A47 Blofield to North Burlingham Dualling

Scheme Number: TR010040

9.24 Request for a Non-Material Change to the Application

REQUEST FOR A NON-MATERIAL CHANGE TO THE APPLICATION

DRAWING TITLE  
**WORKS PLANS REGULATION 5(2)(j) SHEET 5 OF 8**

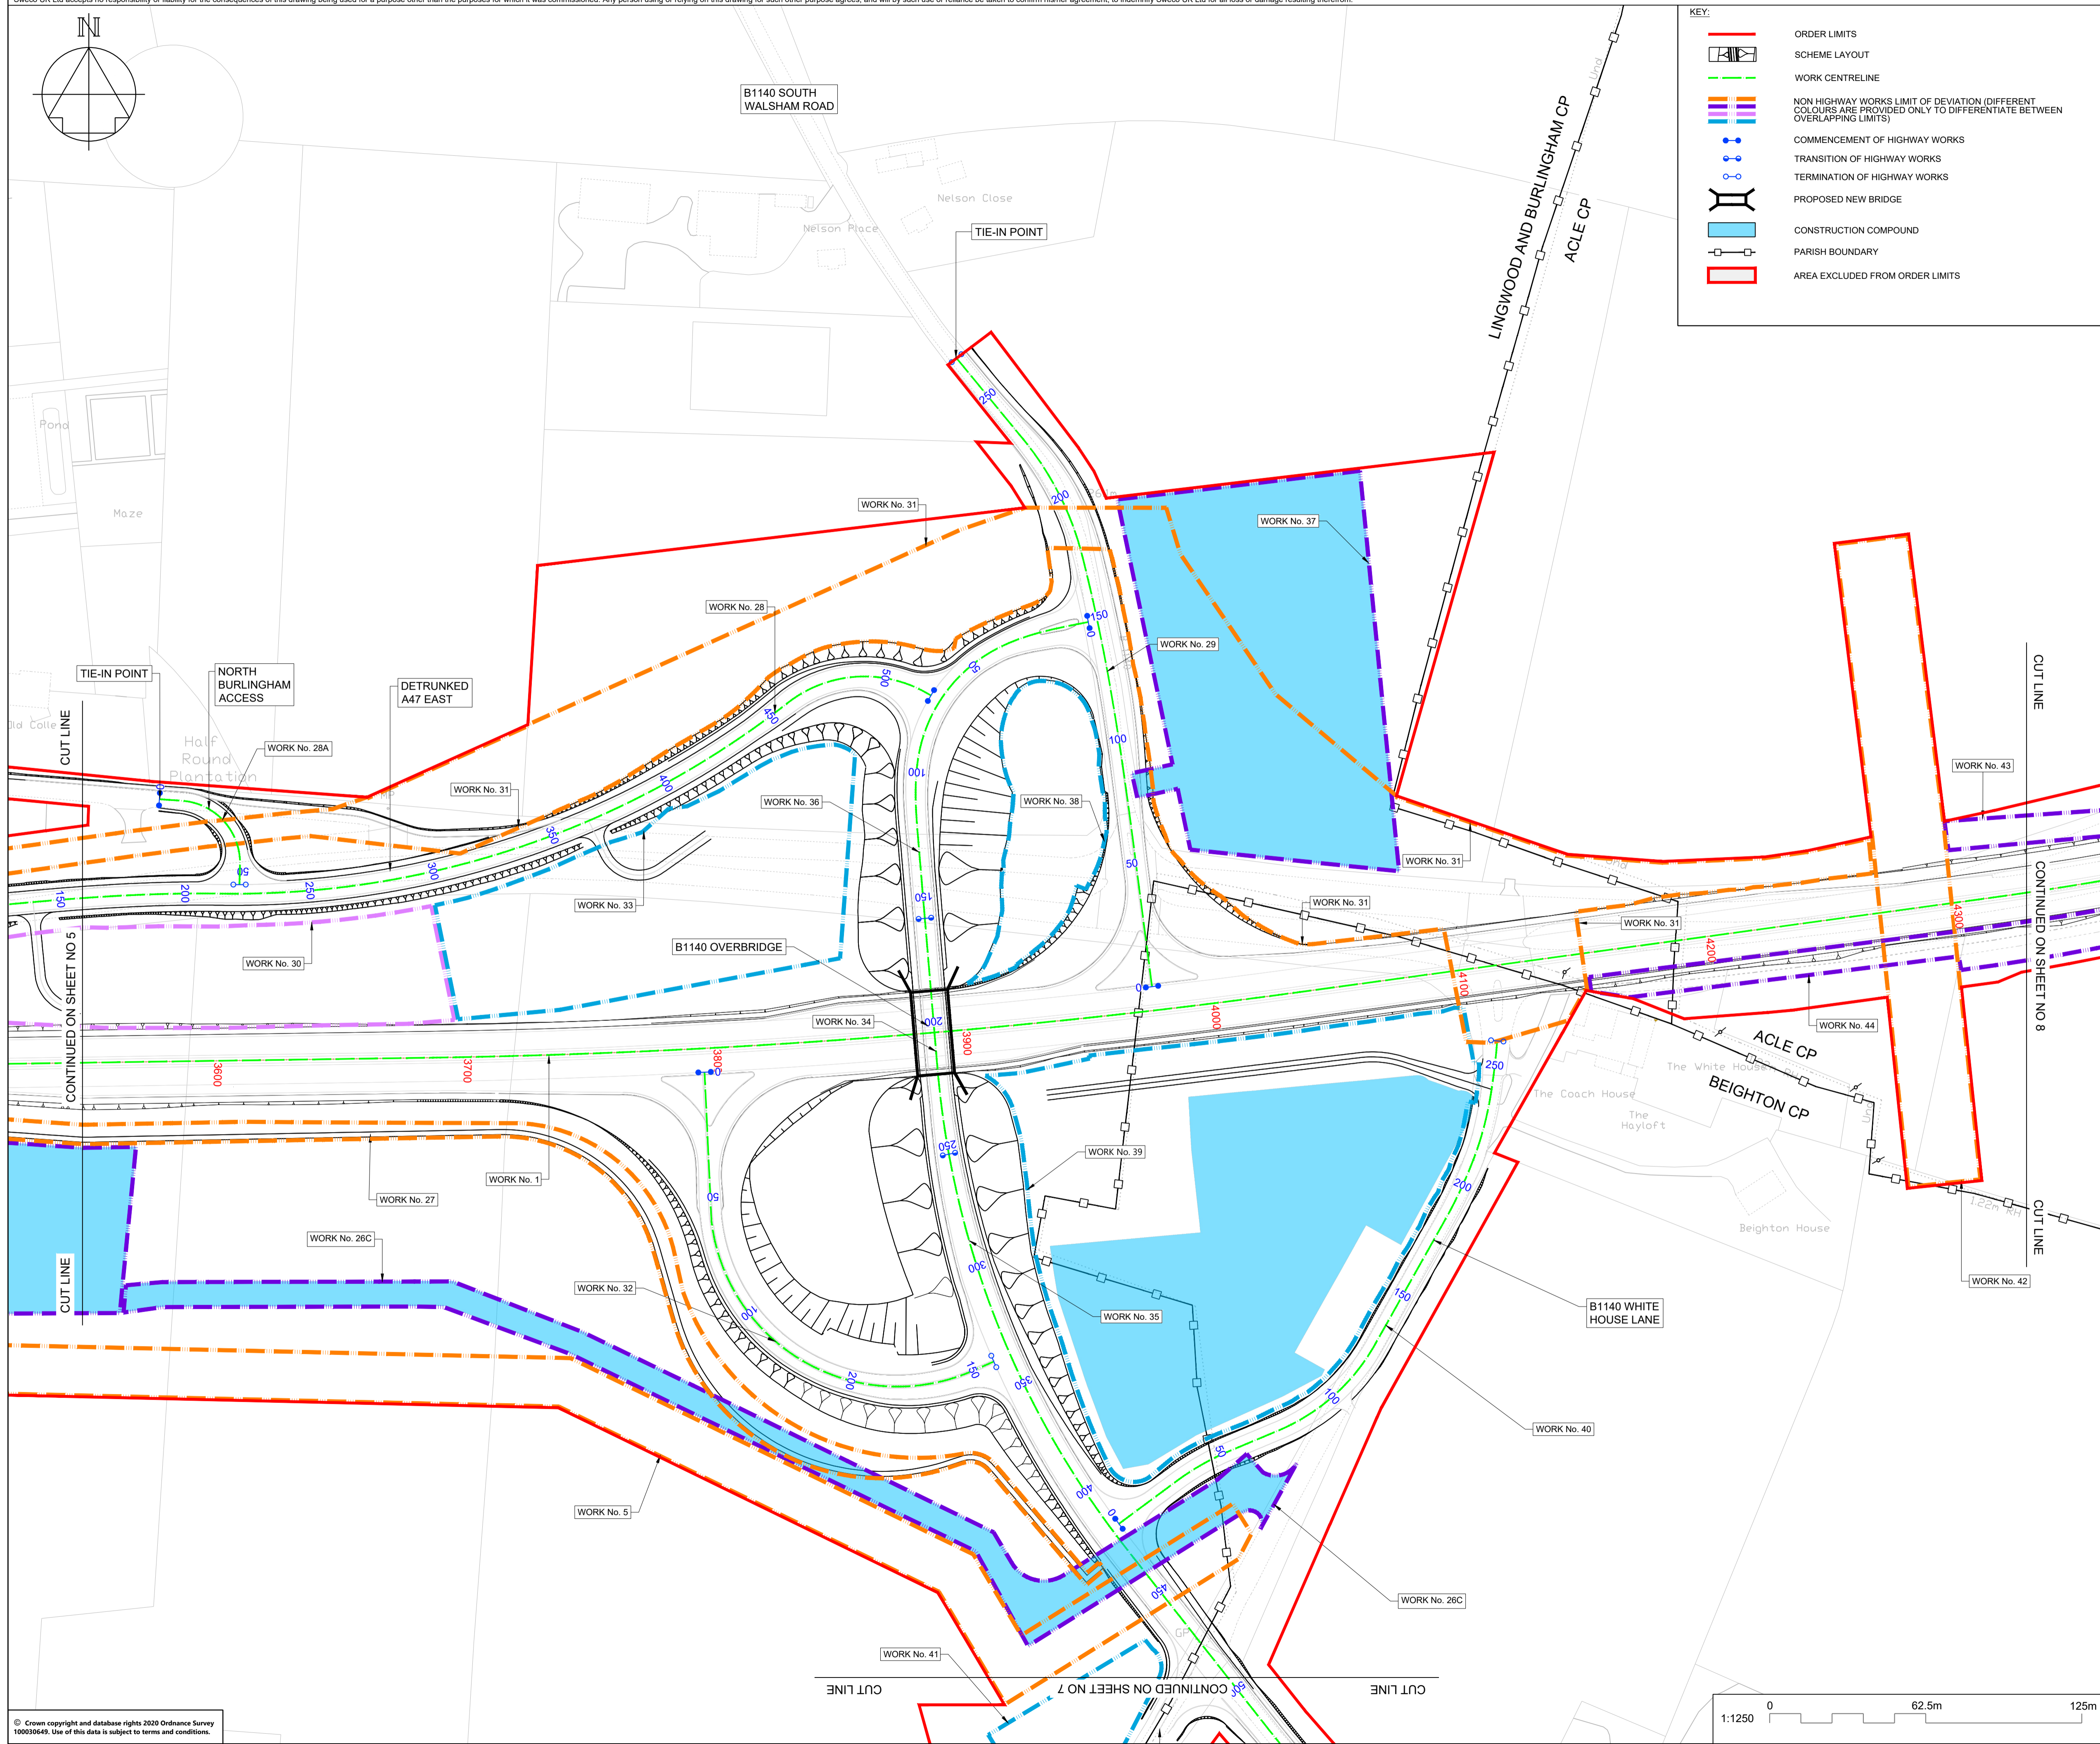
- 2.1.6 While the Applicant included the permanent acquisition of the Existing Block Valve Site in the Book of Reference, because it is required for the construction of Work No.1 (the new A47), Cadent has subsequently advised that the block valve site will need to be re-established on the line of the Diverted Gas Main, where it crosses the North-South Gas Main. The Existing Block Valve Site will therefore need to be relocated further to the south - the New Block Valve Site.

- 2.1.7 To allow the provision of the New Block Valve Site, a new permanent acquisition plot (plot 5/1e) has been added to the Land Plans (**REP4-002**) and the Book of Reference (**REP6-002**) on land for which temporary possession was previously sought. It is anticipated that this land would be vested in Cadent after completion of works. The extent of this plot reflects the limits of deviation for Work No.5, and a degree of uncertainty as to the precise location of the North-South Gas Main (historical records as to the location of the apparatus of statutory undertakers is generally imprecise).

- 2.1.8 In addition to acquiring the New Block Valve Site, it will be necessary to provide a replacement access to the New Block Valve Site (Replacement Access). The Existing Block Valve Site is accessed directly from the existing A47, however this will not be possible for the New Block Valve Site. It is therefore proposed to provide a new access track, leading south from the access track included in Work No. 23. New rights will be required for the new access track between Work No.23 and the Diverted Gas Main, and this has necessitated the creation of a new rights plot (plot 5/1b). Although the description of Work No.5 does not need to change, the limits of deviation for Work No.5, shown on sheet 5 of the Works Plans (**TR010040/APP/2.3 Rev 2**) (submitted at Deadline 7) need to be amended to take into account the land on which the Replacement Access is to be provided.

- 2.1.9 Finally, the new access track will need to provide sufficient room for van and trailer to turn around. As a result it is necessary for the access track to continue over the line of Work No.5 as far as the Order Limits. This land will remain "blue" land (limited to the acquisition of rights and for temporary possession), however in addition to the rights to install and keep the Diverted Gas Main in the land, access rights will also be required over the land. As a result a new rights plot (plot 5/1g) has been added to the Book of Reference (**REP6-002**) and the Land Plans (**REP4-002**).
